Demolition of 1 No. existing house & grounds & erection of 2 No. new detached dwellings. This application may affect the character & appearance of the Station Road, East Preston Conservation Area.

St Marys Close Hurst Road Rustington

Thank you for your internet representation made on 7th October 2018 which has been recorded as '**an objection**' with the comments as follows:

Drawing Title:
ADDITIONAL DWELLINGS
BLOCK/ SITE PLAN

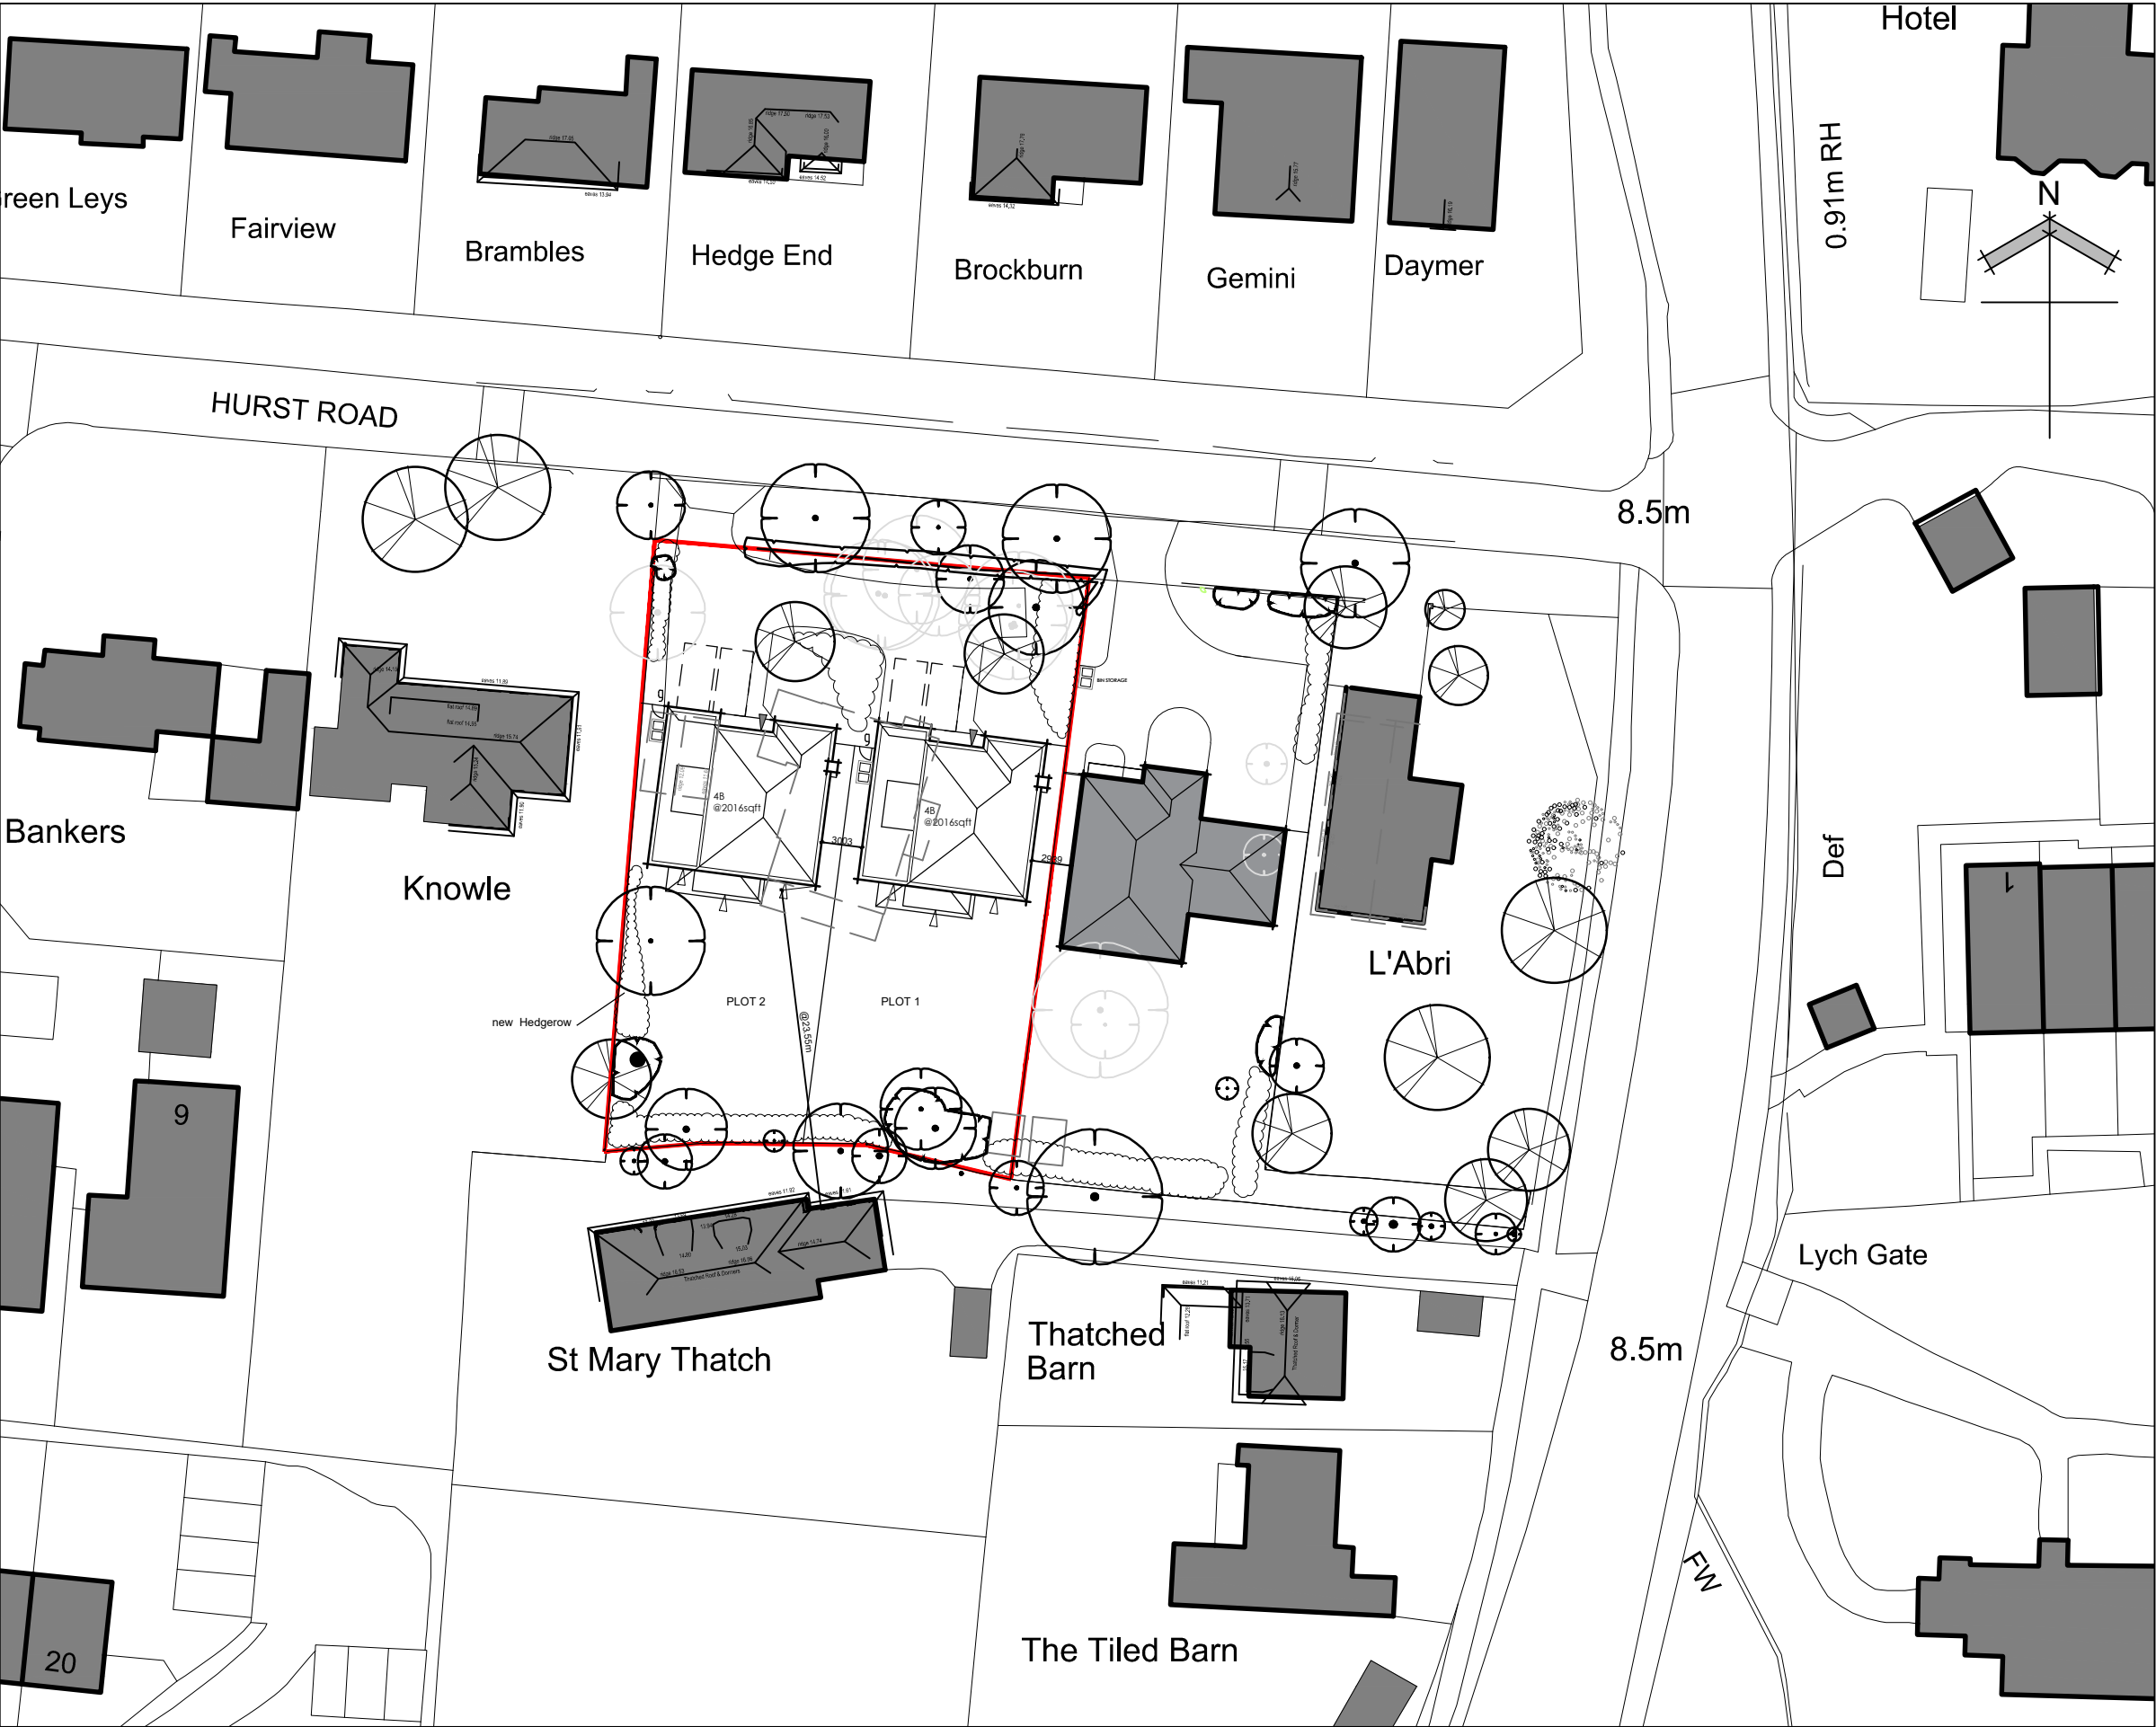
The previous plans for this site (ref: R/64/17/PL) were refused and the reasons given stated that "Hurst Road is characterised by a mixture of houses and bungalows/chalet bungalows of varied designs that occupy quite spacious plots". Whilst the density of the development has been addressed we are still looking at two identical properties which is unprecedented in the road. The development is not set back from the road in the same way as The Cedars and whilst there is presently some screening from the hedge at the front of the property, there would be nothing to stop the eventual owners of the properties choosing to remove this. We would therefore like to register our objection on this basis as it would not be respectful of the existing street scene.
